From: Ian Stocks [REDACTED] **On Behalf Of** FRS Water and Access
Sent: 17 February 2021 16:35
To: Planning.Responses <Planning.Responses@arun.gov.uk>
Subject: Planning consultation - Y/151/20/PL Pollards Nursery Lake Lane Barnham PO22 0AD

Having viewed the plans for the Permanent siting of temporary seasonal horticultural worker accommodation (8 mobile homes & 3 retrospective mobile homes) there appears to be insufficient access for a fire appliance and insufficient supply of water for firefighting.

Scheme **Eric Wall Nursery, Lake Lane, Barnham, PO22 0AD**
Title **Proposed Site Plan (2 of 2)**

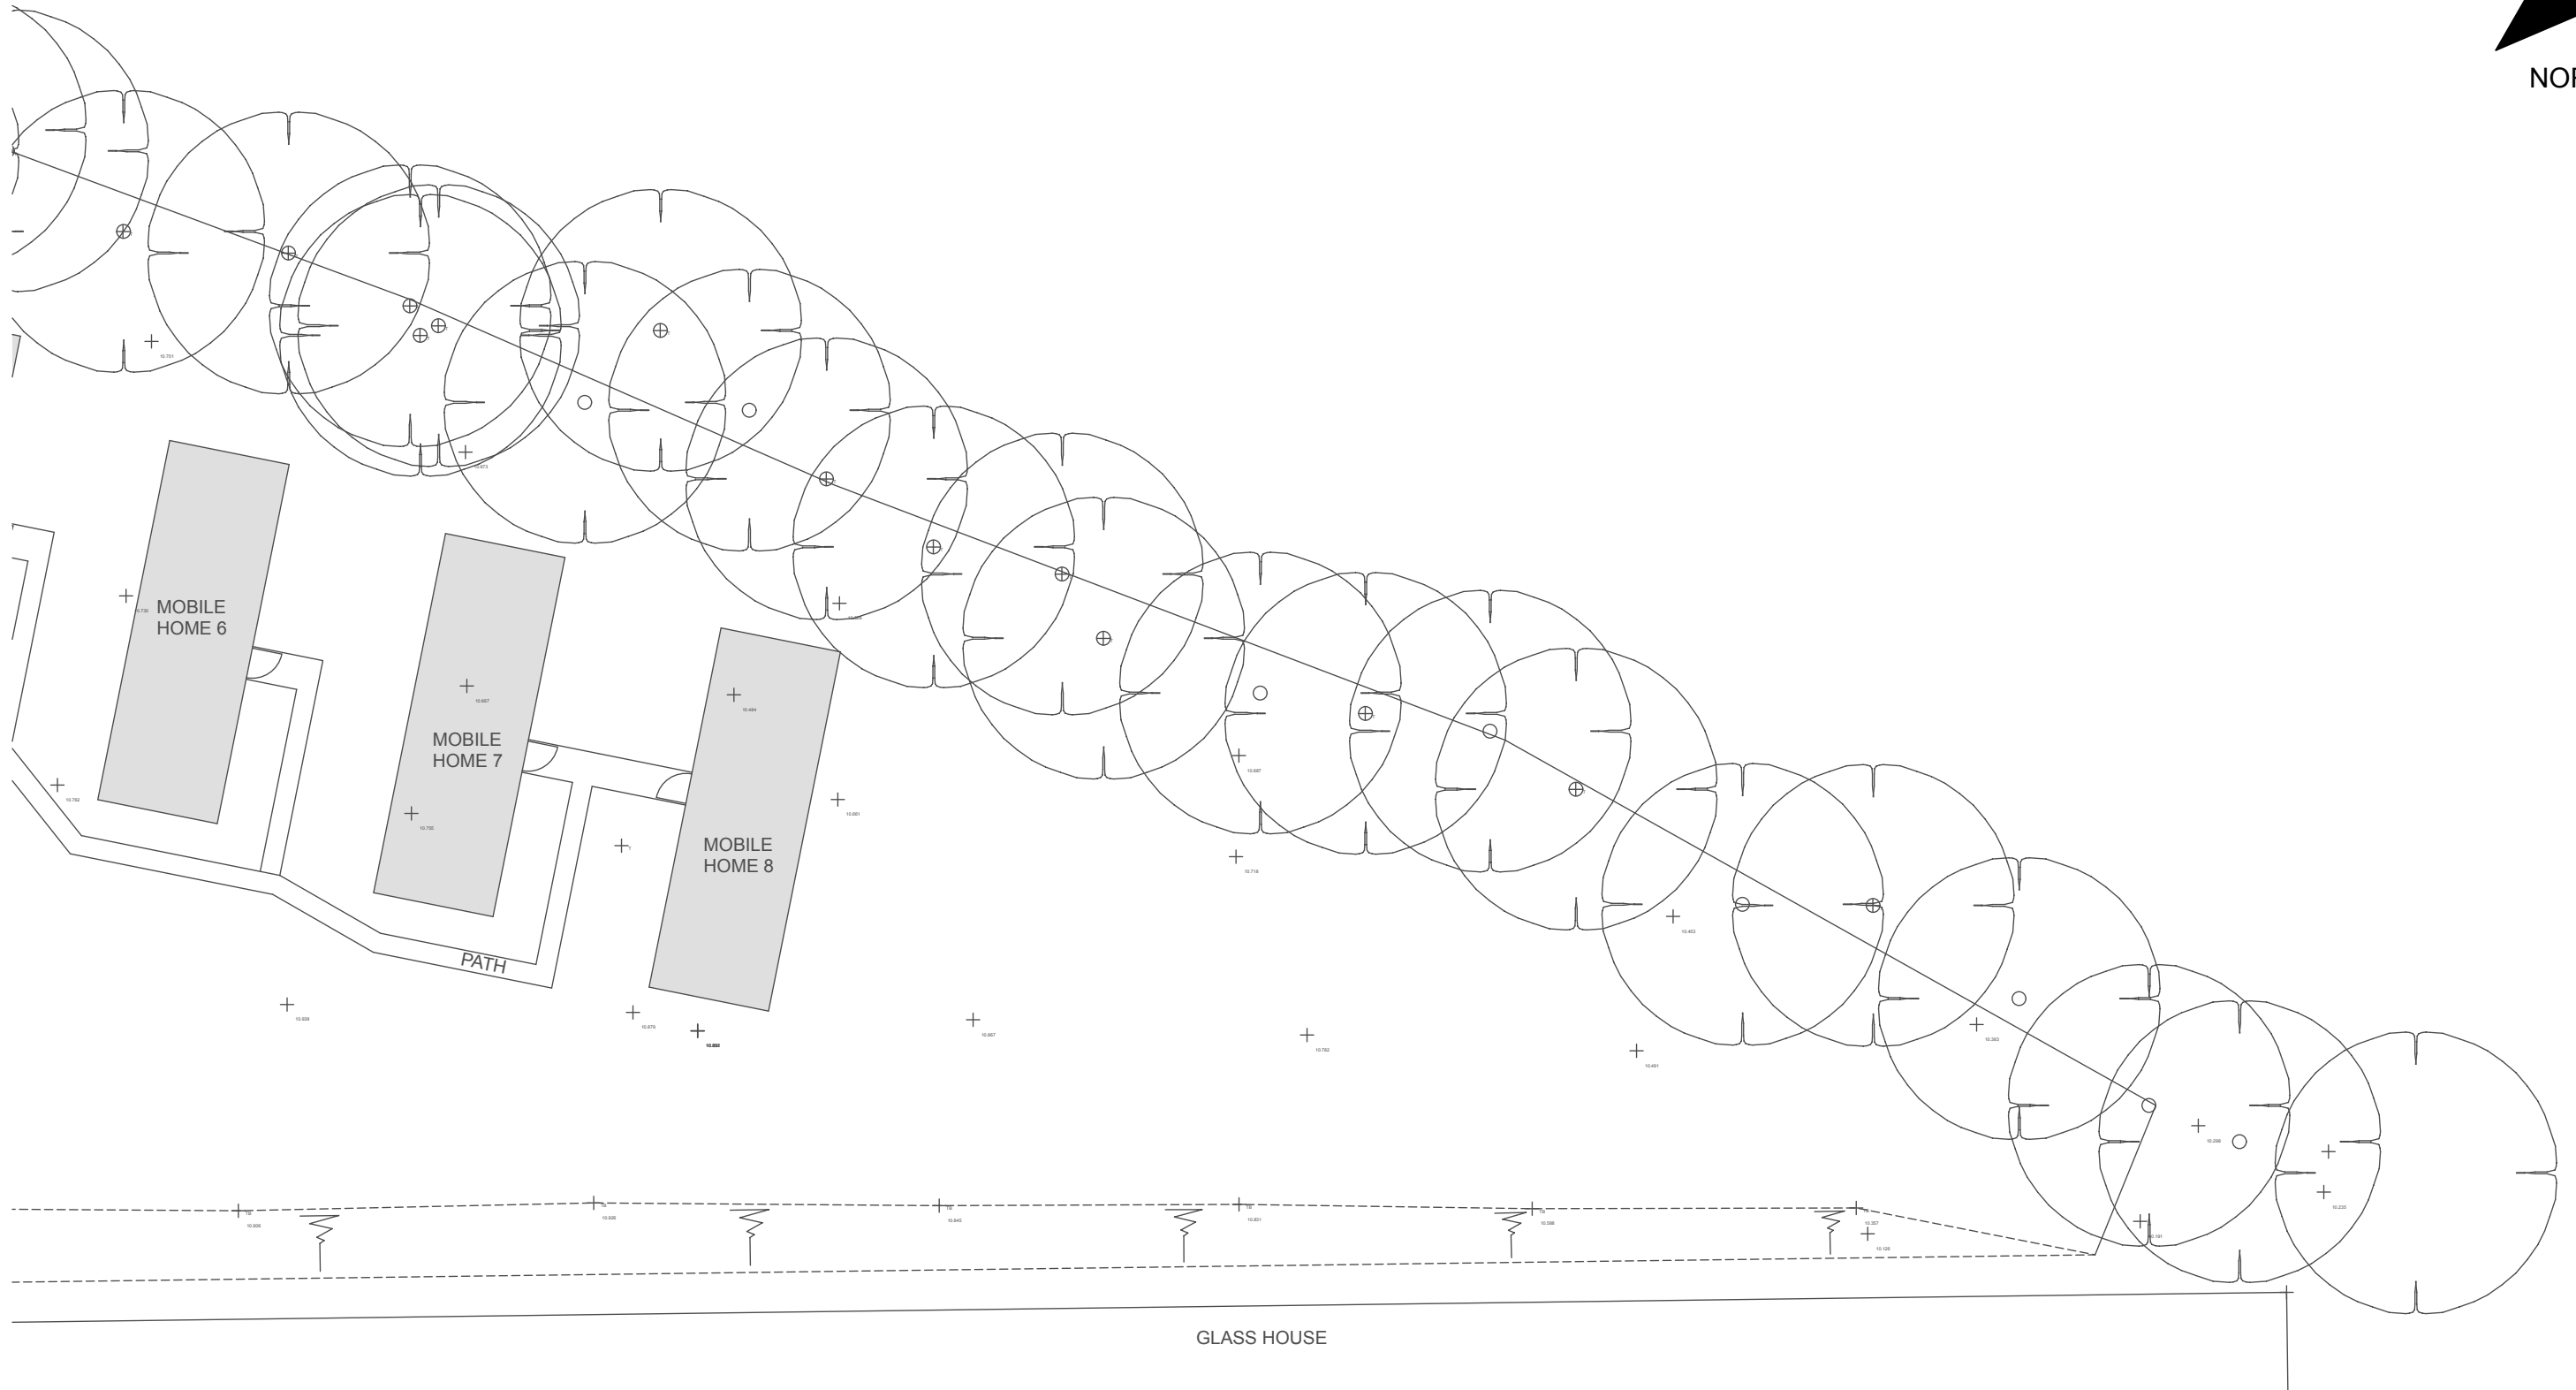
Evidence is required showing suitable access for a Fire Appliance to gain access to the site in accordance with the requirements of Approved Document – B: B5 section 13 Vehicle access. Although these are static mobile homes they are for staff accommodation and therefore require Fire Service access. The access route will need to be sufficiently wide enough to allow a fire appliance to gain access, a minimum width of 3.7 metres and 3.1 metres trough a gate (AD-B Vol. 1 Table 13.1) and must be capable of withstanding 12.5 tonne axial weight.

There is also Insufficient supply of water for firefighting for this site, there is a fire hydrant on the main road, approximately 150 metres away from the site but there is no evidence of an Emergency vehicle access to the site. Any commercial premises should be within 90 metres of a fire hydrant or an alternative water supply or 150 metres for a domestic premises. Evidence is therefore required on how this will be achieved.
